Public Works Engineering  
Traffic Technical Memorandum  
(LSC #5214200)  
March 26, 2021  
PCD File No. SF-21-021

PCD File No. SF-21-021

Figure 4
**Assignment of
 Filing No. 2 Site-Generated Traffic**
 Retreat at Timber Ridge Filing No. 2 (LSC #S214200)

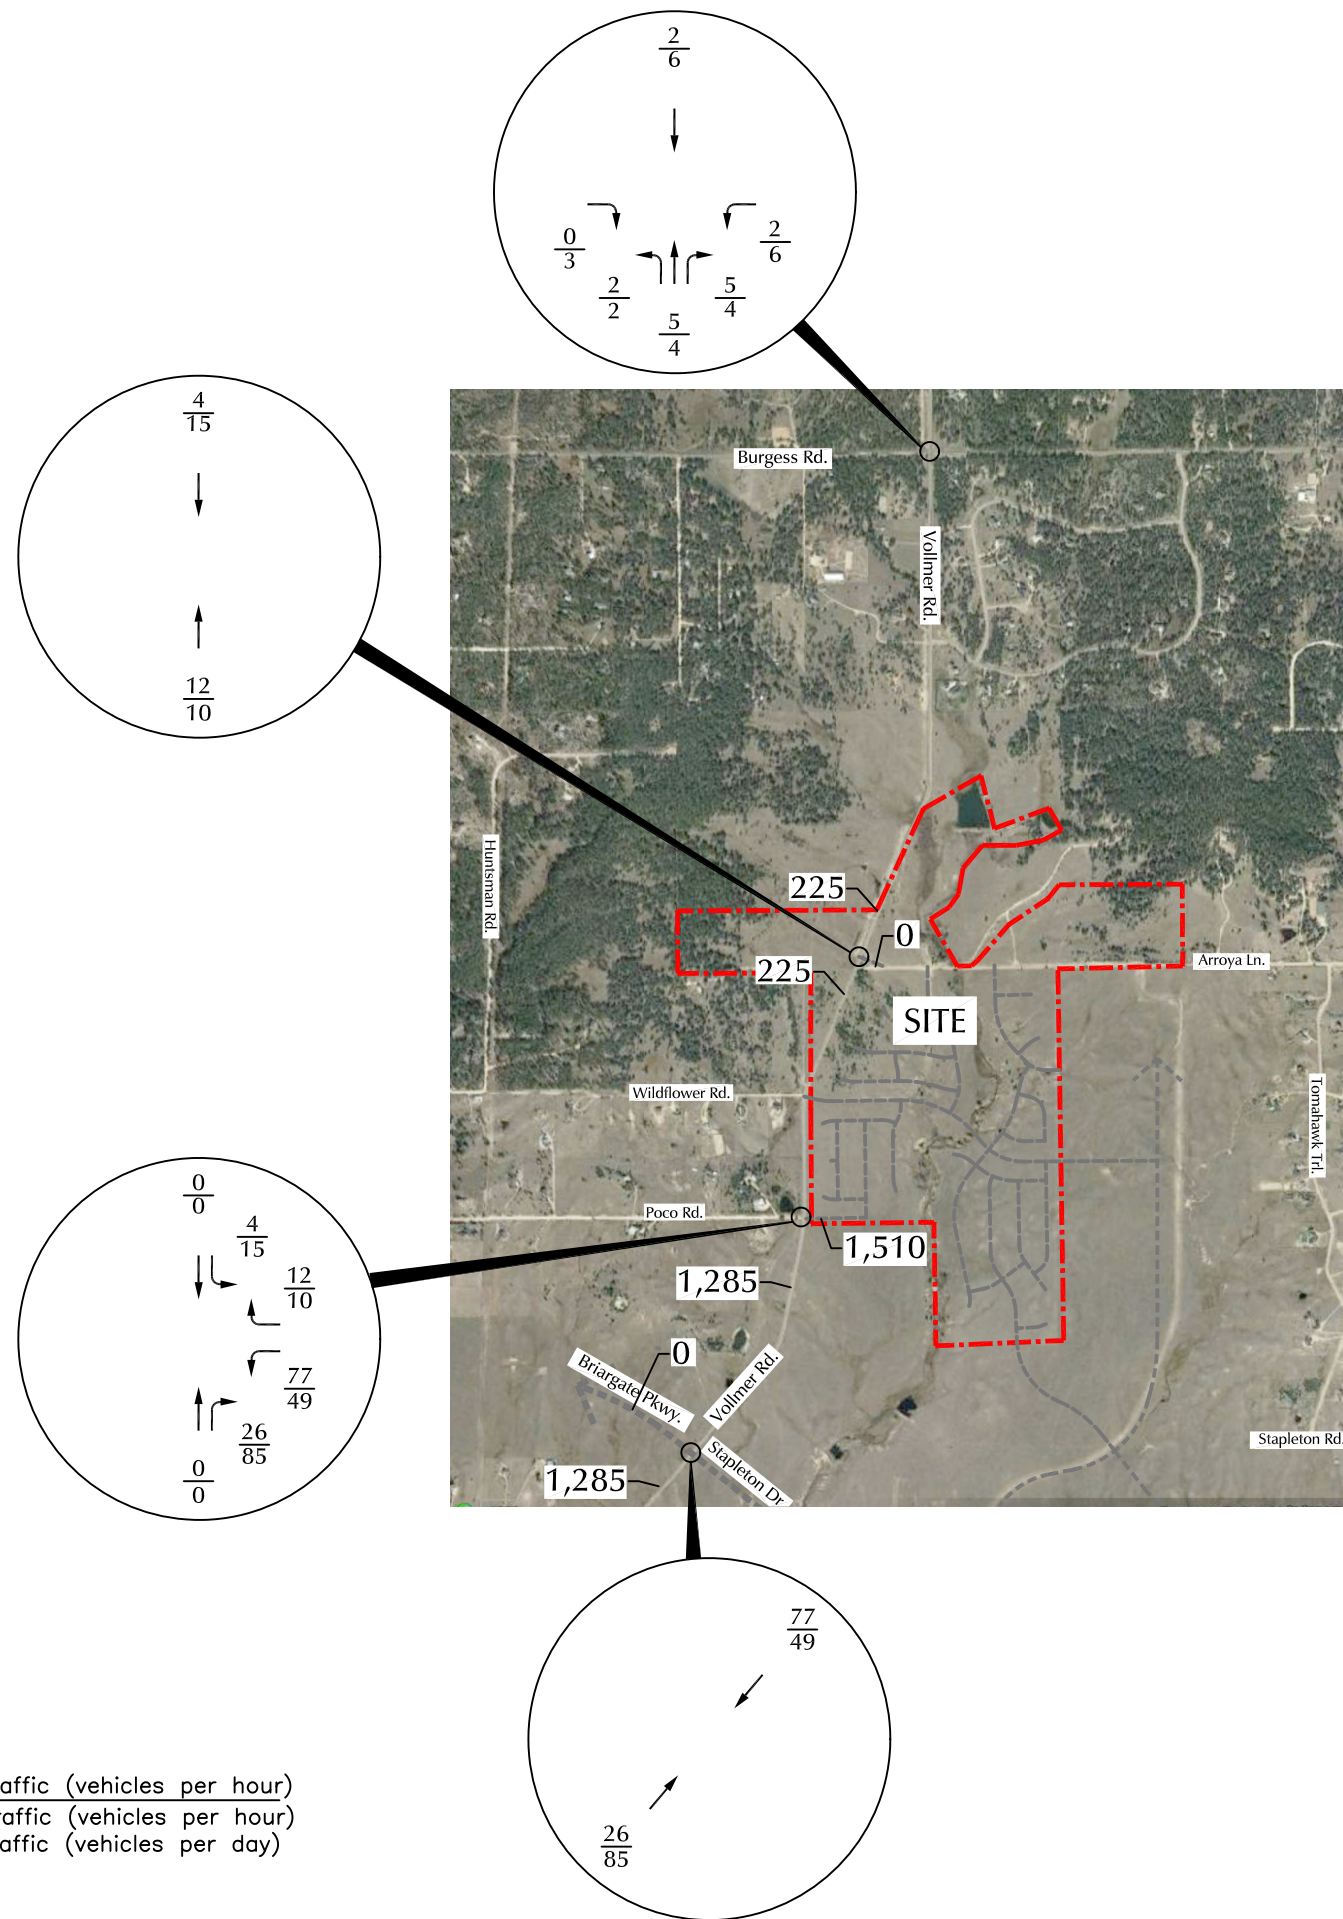
Provide figure for Background + Filings 1 and 2

Provide figure for Background + Filings 1 and 2
